April 24, 2025

RE: Taco Bell / Retail Development, Snow Vista Blvd SW, Albuquerque, NM
Final Traffic Impact Study (L09D023)

Wallace Design Collective has reviewed the comments provided by Curtis Cherne on 03/14/2025. Our comment responses to these comments are as follows:

# C400

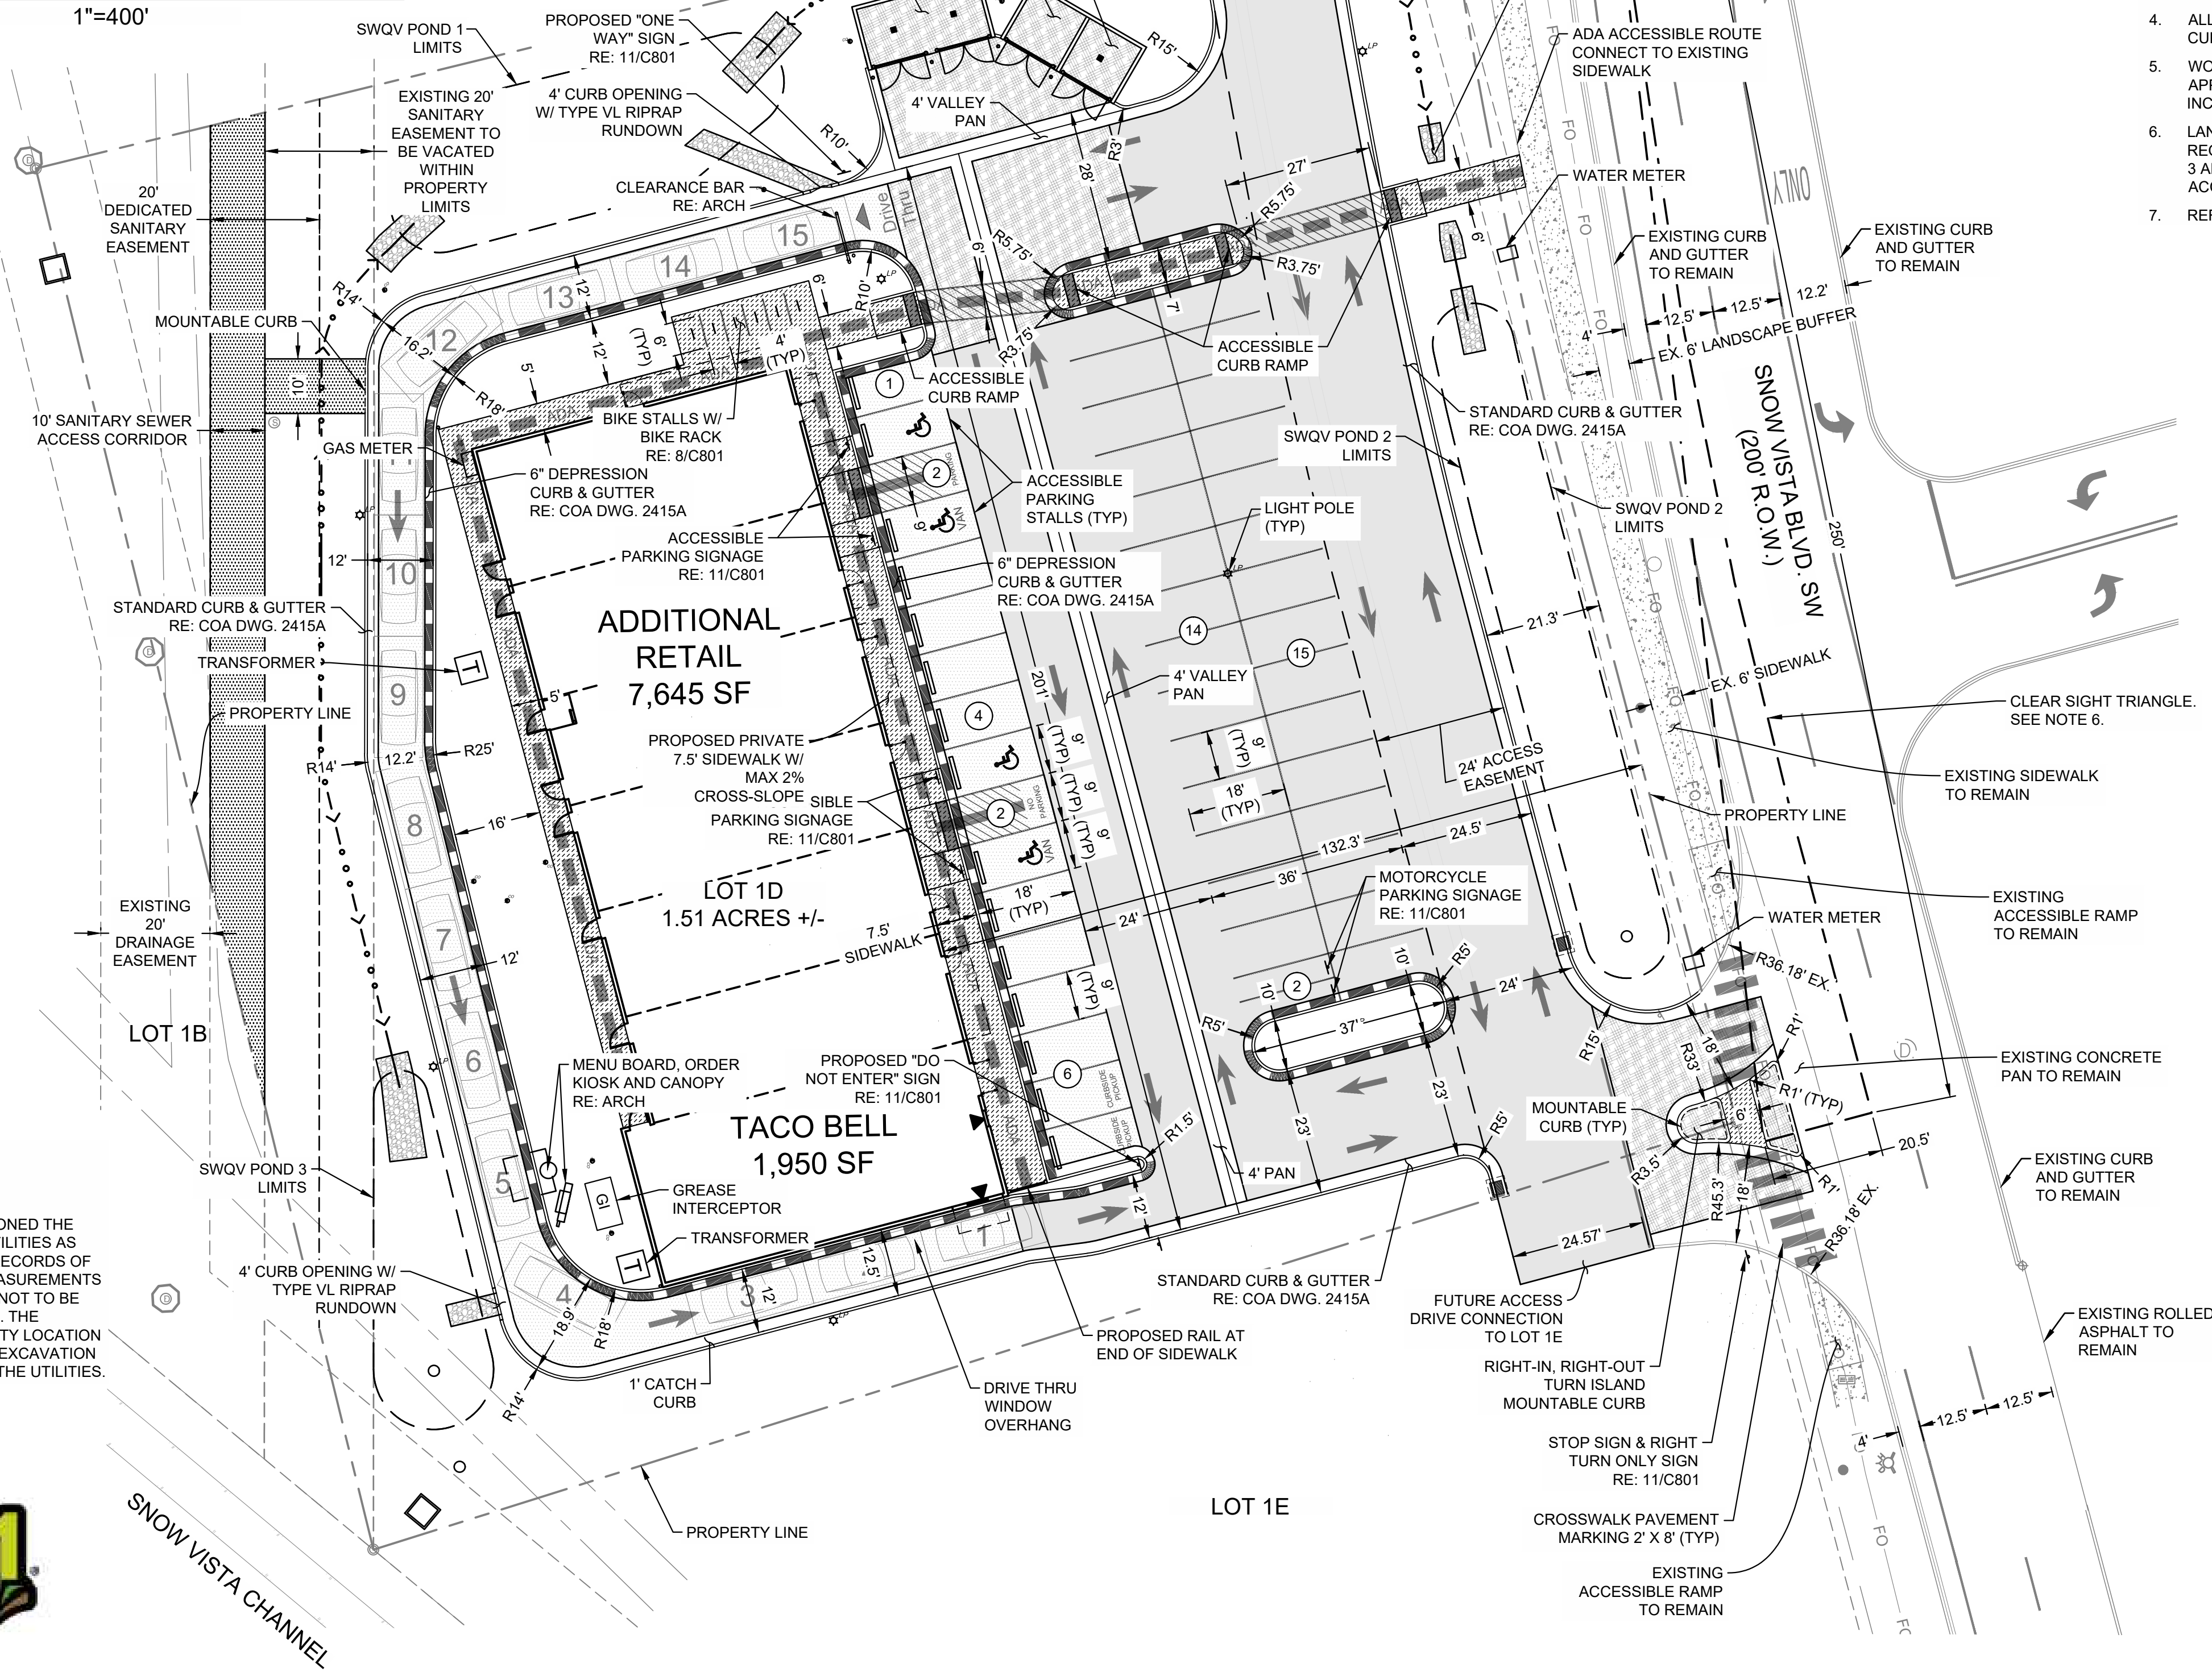
4. As discussed at the scoping meeting, provide hardscape to enforce the right-in/right-out at Access #1. The northern beginning of the radius for Access 1 is approximately

in the same location as the southern beginning of the curb return of the median opening. This is too easy to shortcut.

-The driveway appears to be approximately 30 feet wide. This is wide enough for a pedestrian refuge/porkchop

Response: A "porkchop" with pedestrian refuge was added at Access #1 to encourage right-in/right-out traffic movements at this access point.

SITE PLAN

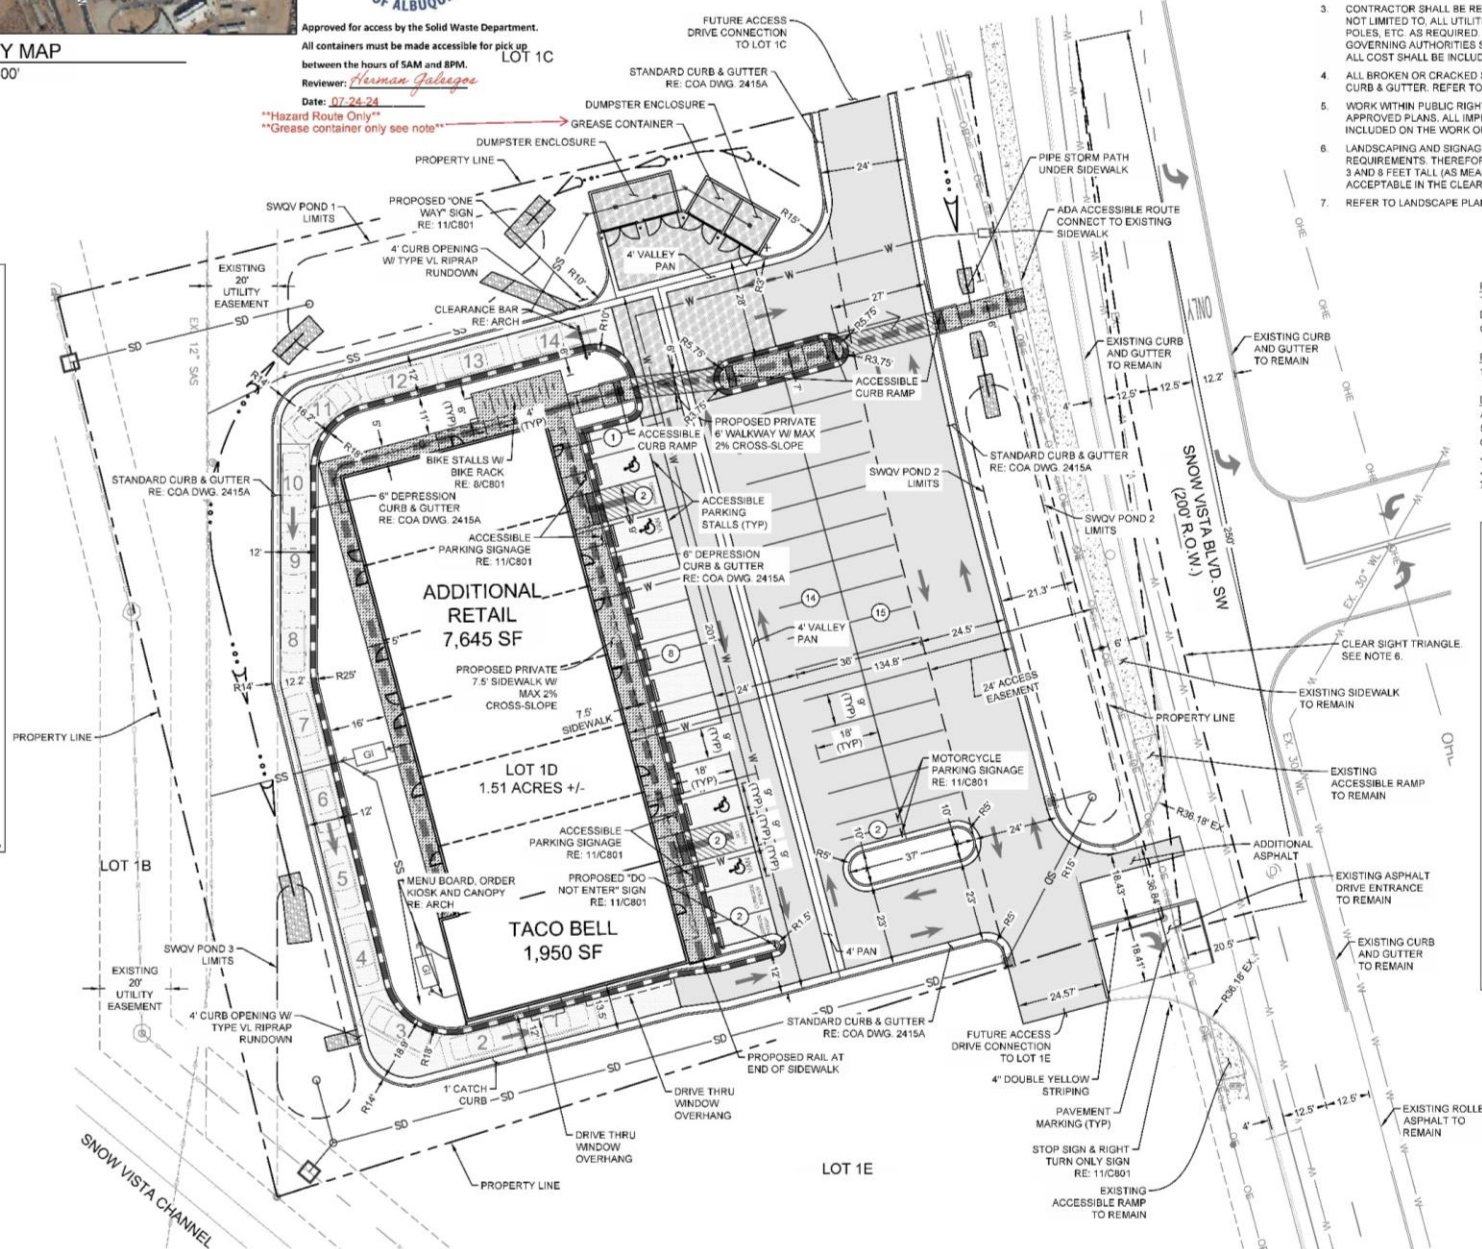
3. Provide an 11"x 17" minimum size site plan that is more legible than the current one.

Response: A full-size Site Plan was added to the report.
